Application for North Falls Offshore Windfarm

Essex County Council (ECC) and Tendring District Council (TDC) Joint Response to ExQ3 issued on 1 July 2025

Document Reference:	9.30
Volume:	9
Date:	May 2025
Revision:	2

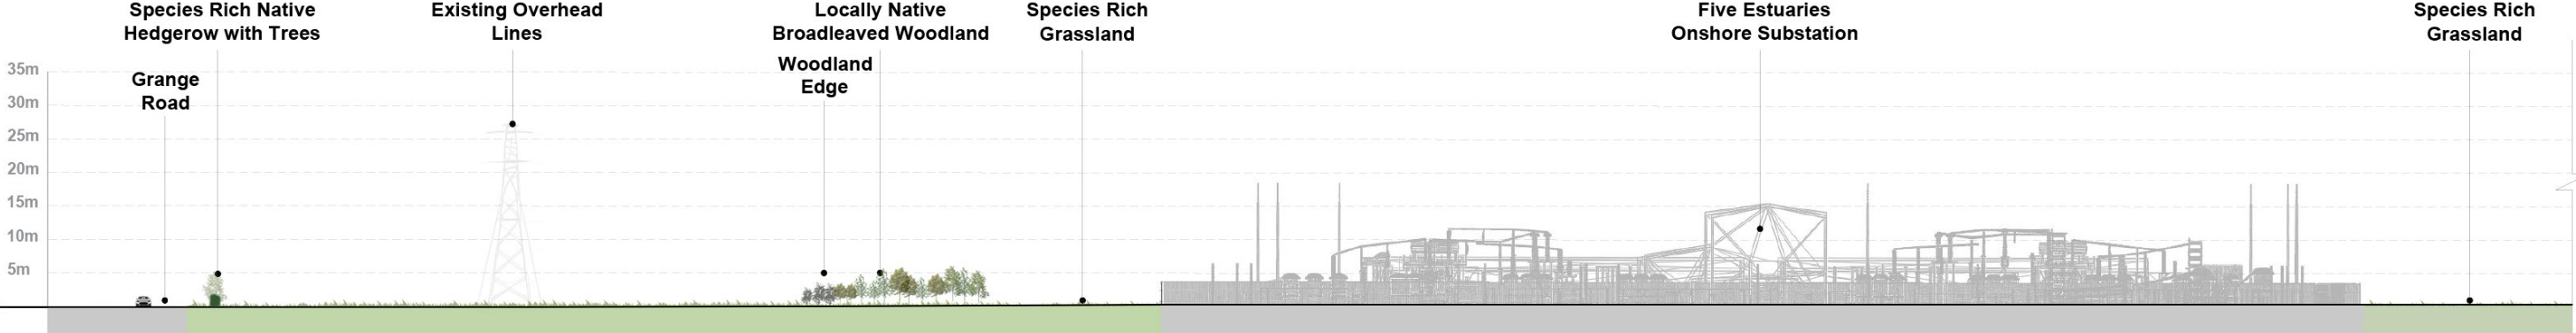
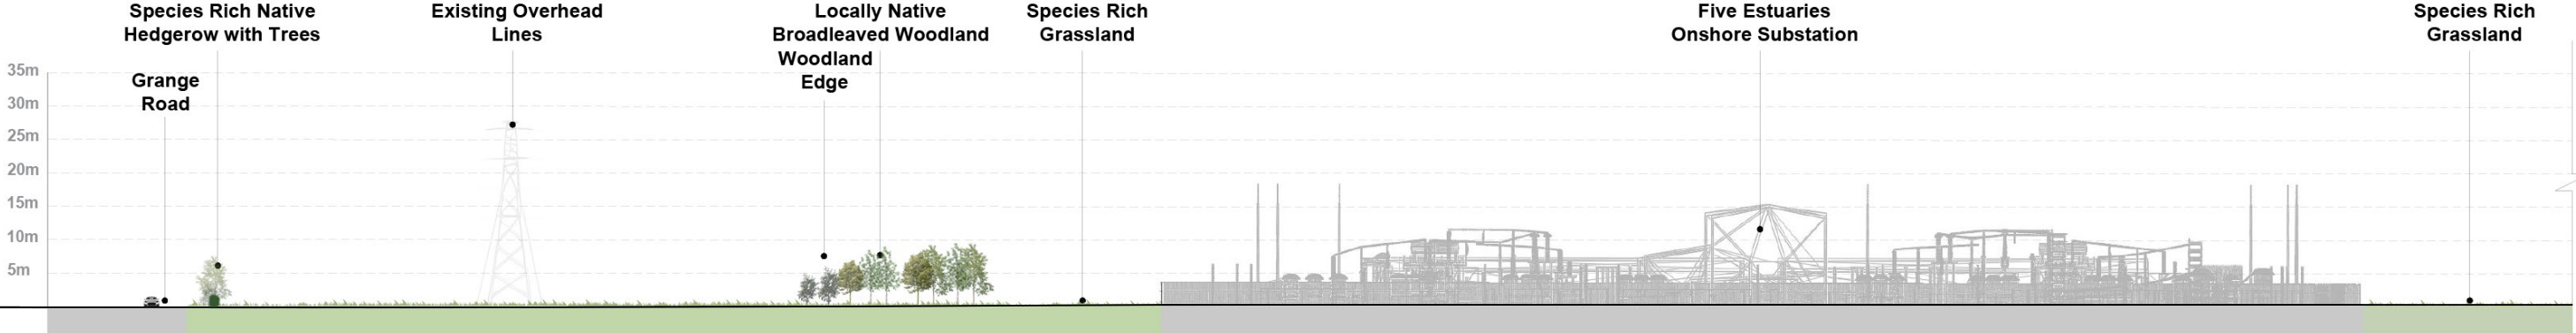
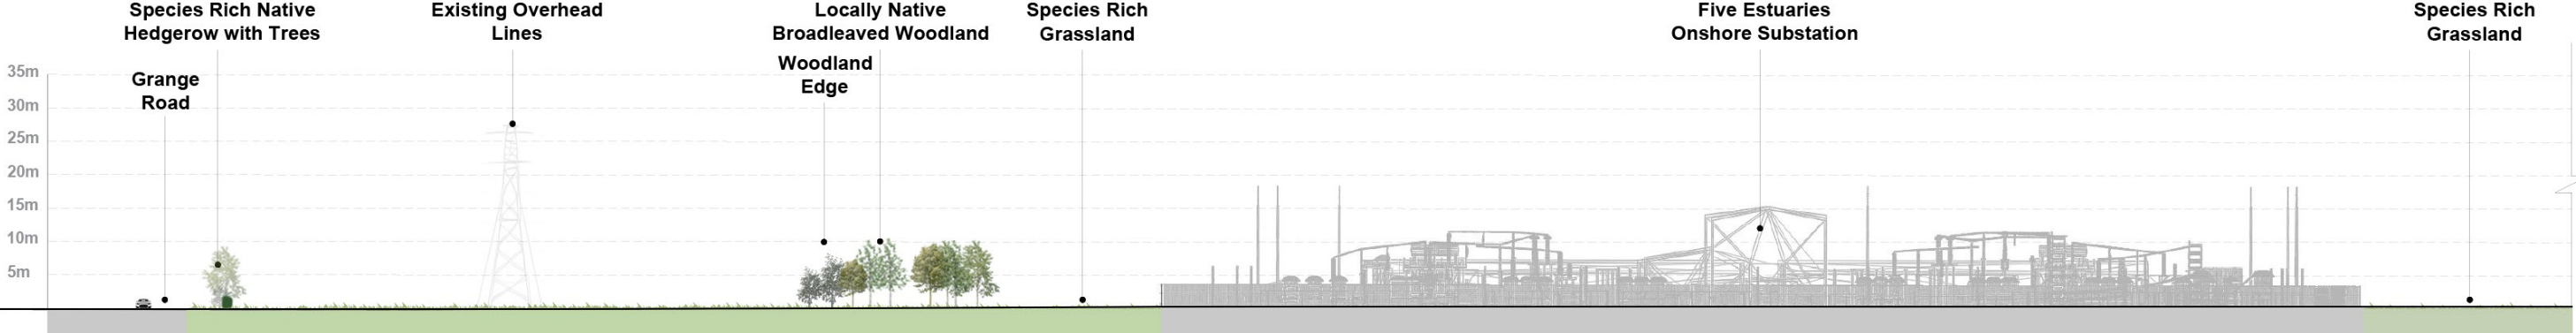
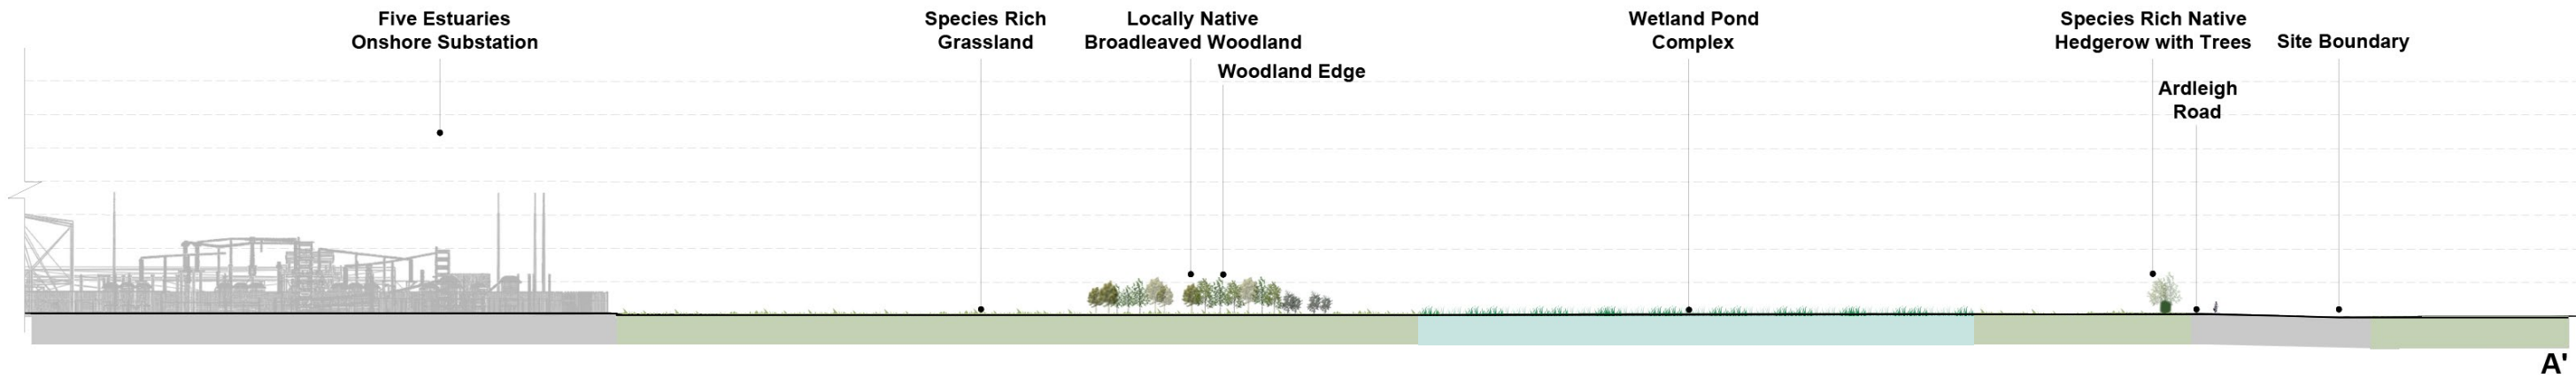
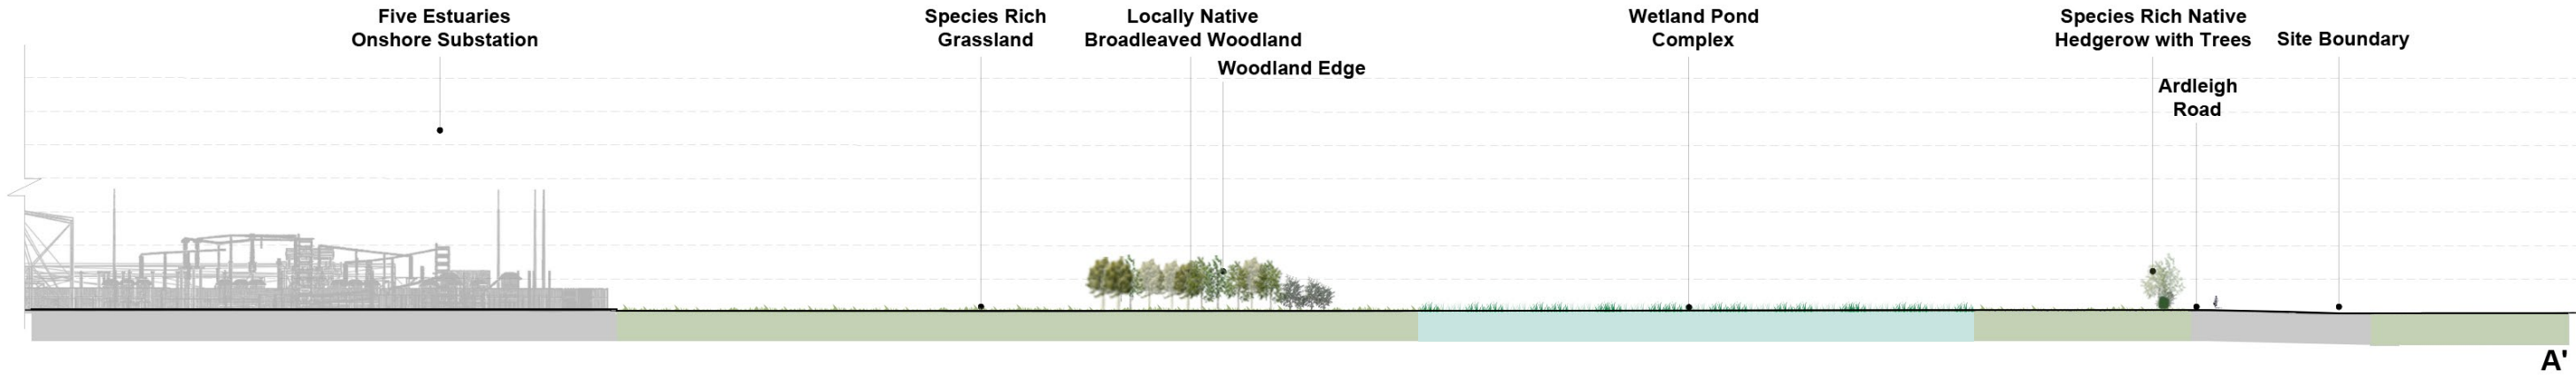
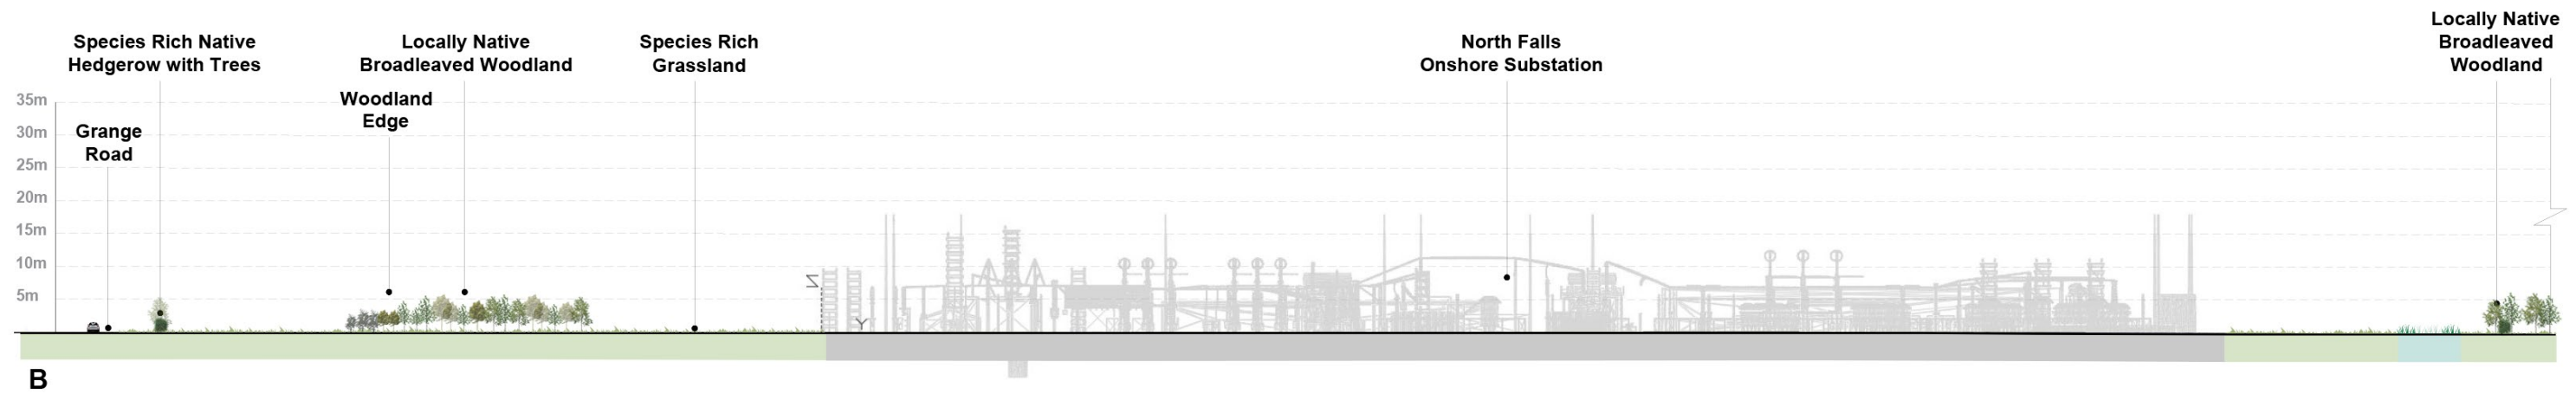
13.	Human Health	
14.	Landscape and Visual	
Q14.0.1	Applicant	<p>Visual Mitigation at Substation</p> <p>The ExA notes the update to 9.30 Indicative Planting cross-sections at the onshore substation (Rev 2) [REP5-035] at Deadline 5. This confirms that planting would not be orchard planting but a series of woodland belts.</p>

ExQ3	Question to:	Question:
		<p>i) Please can the Applicant elaborate, setting out timescales to maturity and at what point the screening will have taken full effect.</p> <p>ii) With regard to the Written Landscape Scheme, could the OLEMS clarify the details of trees, woodland and hedgerows, finished ground levels and bunding, and plant details including, where possible plant schedule will also be provided as drawings to illustrate the written details. Could boundary treatments also be included on the drawings for clarity.</p>
	ECC & TDC Response:	<p>i) The Councils understand that the applicant has estimated that the woodland/shelterbelt planting will reach approximately 6-8m after 15 years. The Indicative Planting cross-sections at the onshore substation (Rev 2) [REP5-035] and the visualisations supplied with the ES demonstrate that the proposed planting never fully conceals the substation.</p> <p>ii) The Councils are concerned that without appropriate scaled drawings being required to associate with the Final LEMS, the full intention of the proposed landscape strategy and its successful implementation at the delivery stage cannot be guaranteed.</p>
